Five Estuaries Windfarm DCO

PINS Ref: EN010115

Date: 3 December 2024

Planning Act 2008**Application by Five Estuaries Offshore Wind Farm Limited for an order granting development consent for the Five Estuaries Offshore Wind Farm project.**

Completed pre-consent archaeological trial trenching and palaeolithic test pitting

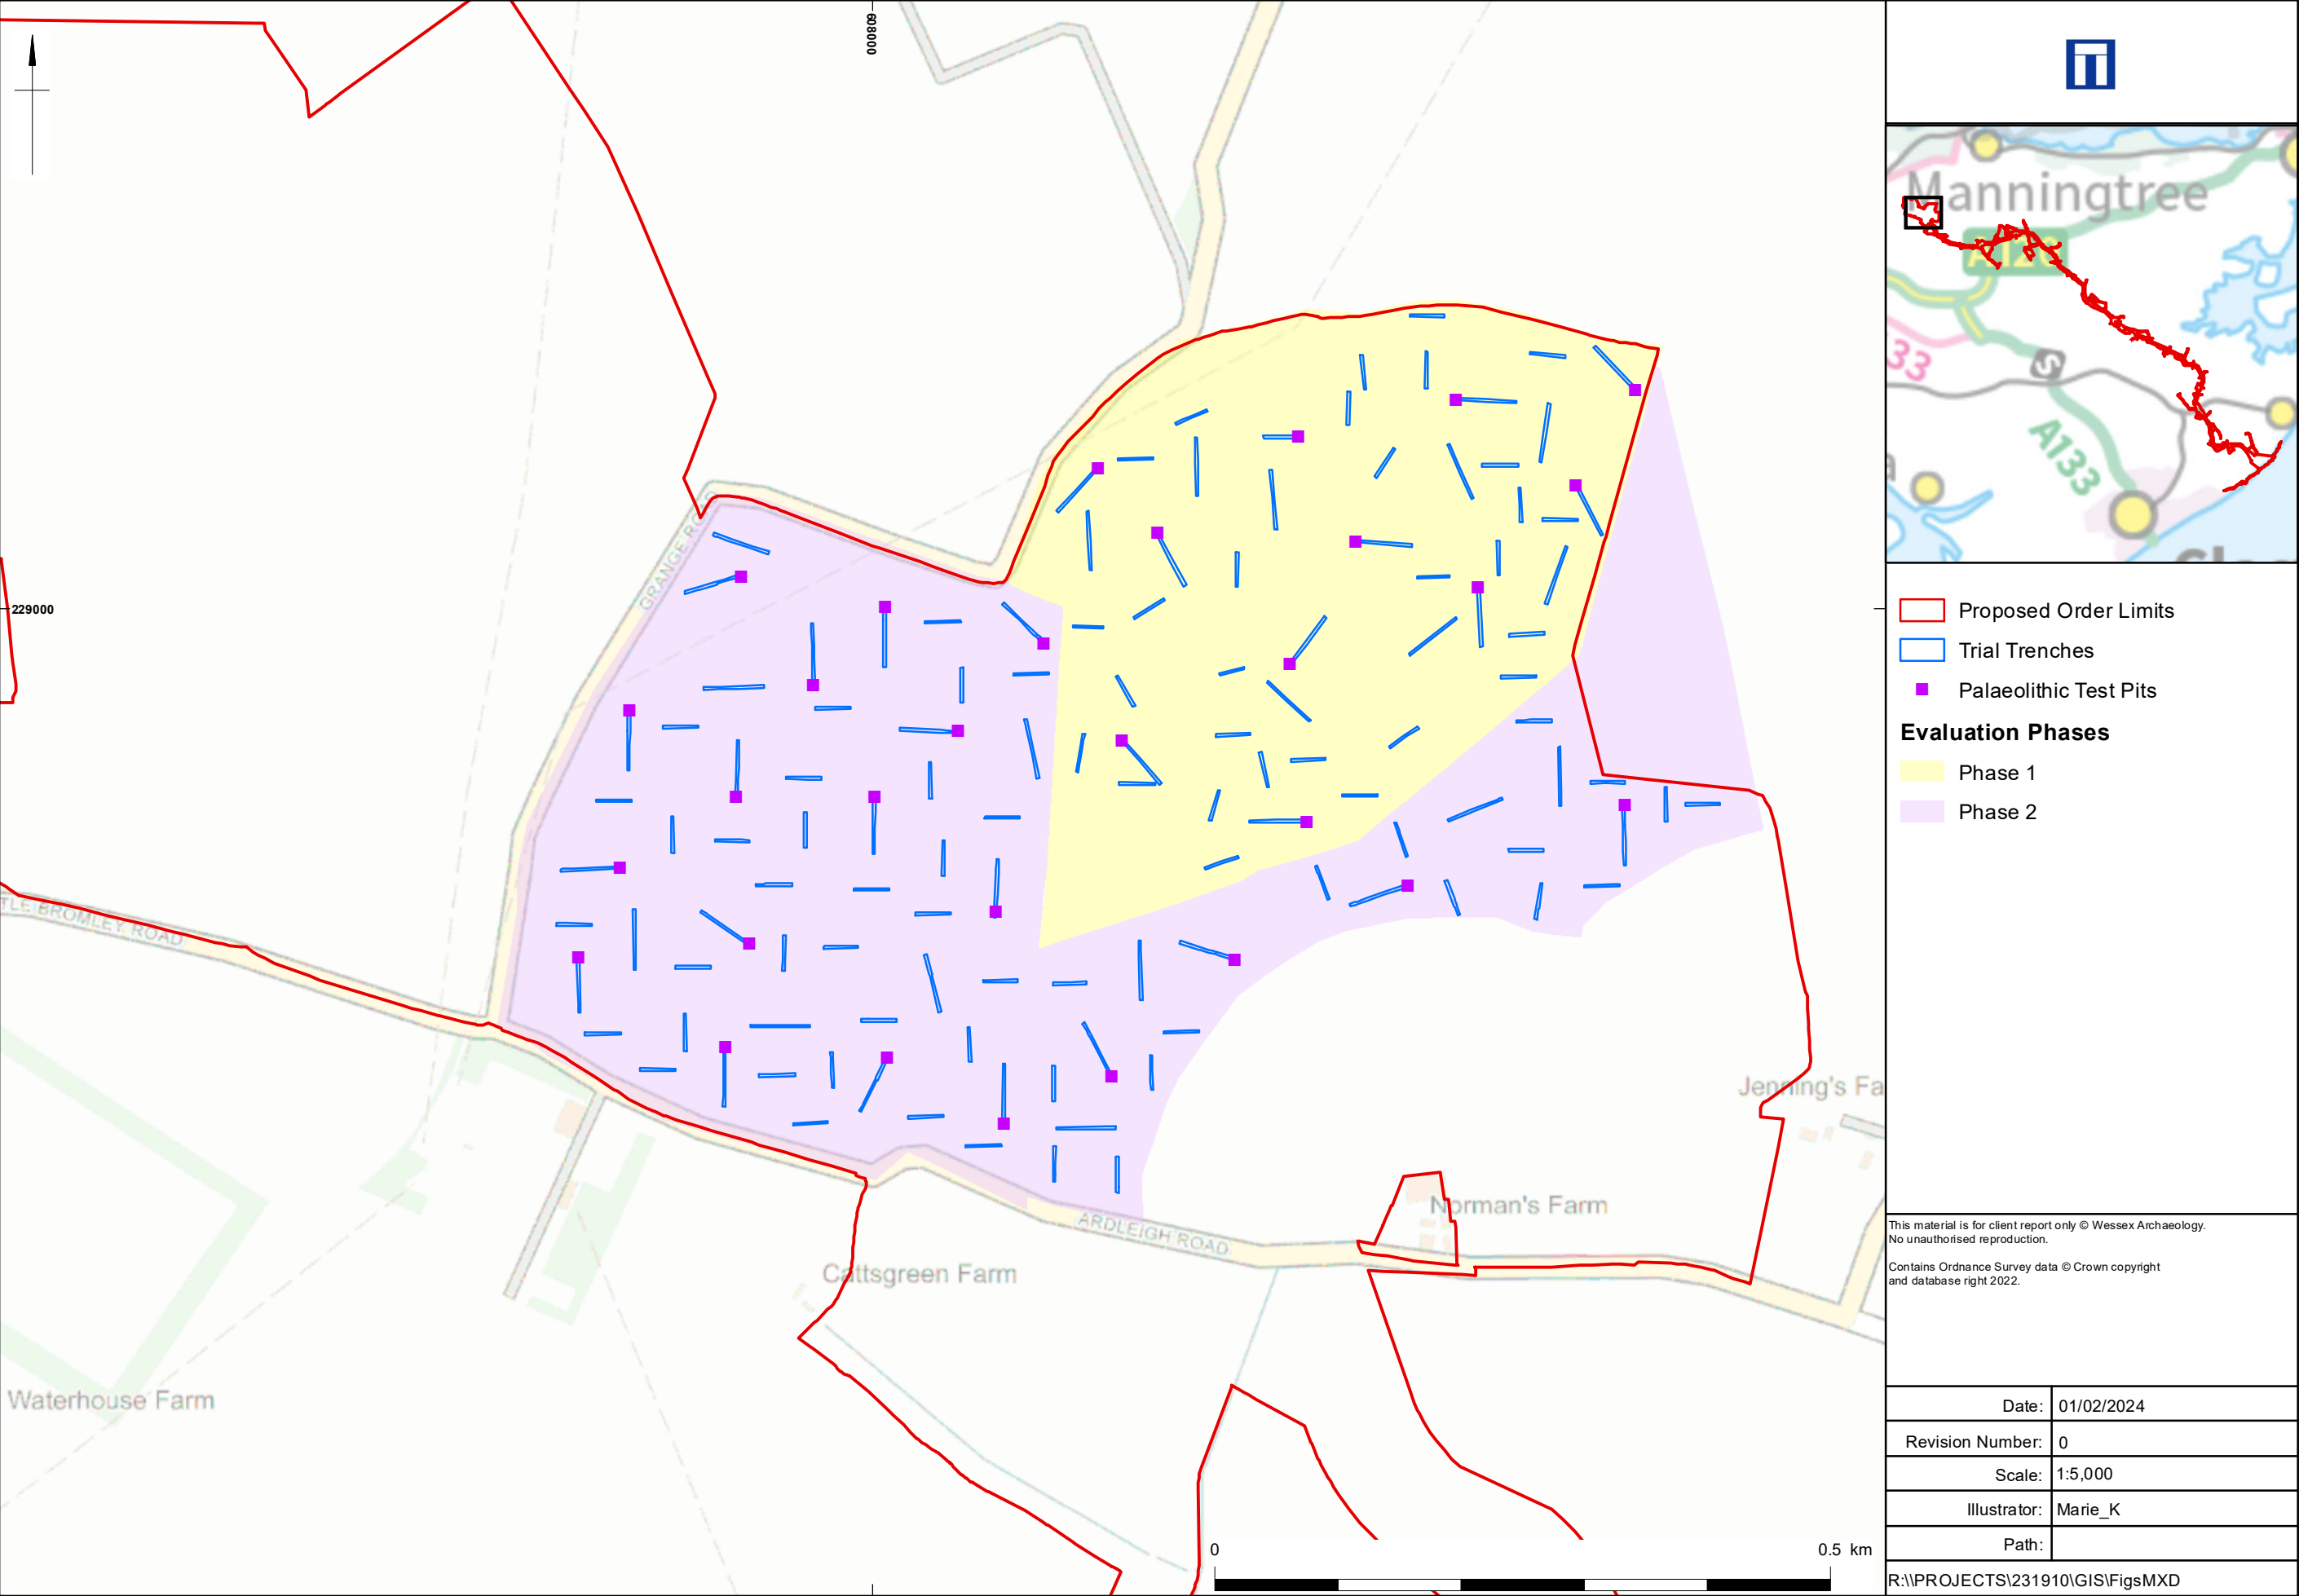
The level of information submitted with the DCO fails to provide sufficient information on the nature, extent and significance of heritage assets in order to determine the impact on archaeological remains by the proposed scheme. This is due to factors such as incomplete coverage of the whole route by geophysical survey and lack of physical evidence to corroborate the validity of the non-intrusive techniques that were employed.

The heritage assets included in the assessment have been identified largely through geophysical survey and aerial photographic interpretation. Geophysical survey would not be considered a suitable method of evaluation without an element of ground truthing in order to determine the effectiveness of this method in identifying archaeological remains and further, to assess the presence of further archaeological remains that may not have been identified through this method.

The limited trial trench evaluations have provided sufficient information in the areas where they were completed, however as they were conducted in areas where there was a relatively low incidence of archaeological remains as identified through geophysical survey they have not positively contributed to the assessment of this technique as an evaluation method.

Due to the limited amount of intrusive archaeological fieldwork completed the information submitted fails to provide sufficient information on the potential for as yet unknown archaeological remains and does not provide confidence that the mitigation proposed would be sufficient or achievable. While the methodologies proposed in the OWSI are appropriate, it remains to be demonstrated that any currently unknown significant and extensive archaeological remains can be avoided through micro-siting. If this is not achievable then this may result in the loss of significant archaeological remains, while this evidence may be considered 'preserved' by record through excavation the ability to record evidence of our past should not be a factor in deciding whether such loss should be permitted (NPPF, 2003 211)

At present the investigations carried out and information submitted have not provided a suitable level of information on the potential for archaeological remains along the entire route and it remains to be demonstrated that the embedded mitigation through micro-siting will be feasible or achievable in all areas.

It is for the applicant to demonstrate that any known and as yet unknown archaeological remains of high significance can be preserved in situ through micro-siting. The route needs to be examined to assess areas where micro-siting may not be achievable and where this is the case to provide a suitable level of information prior to the close of the examination in order to determine the impact on archaeological remains.
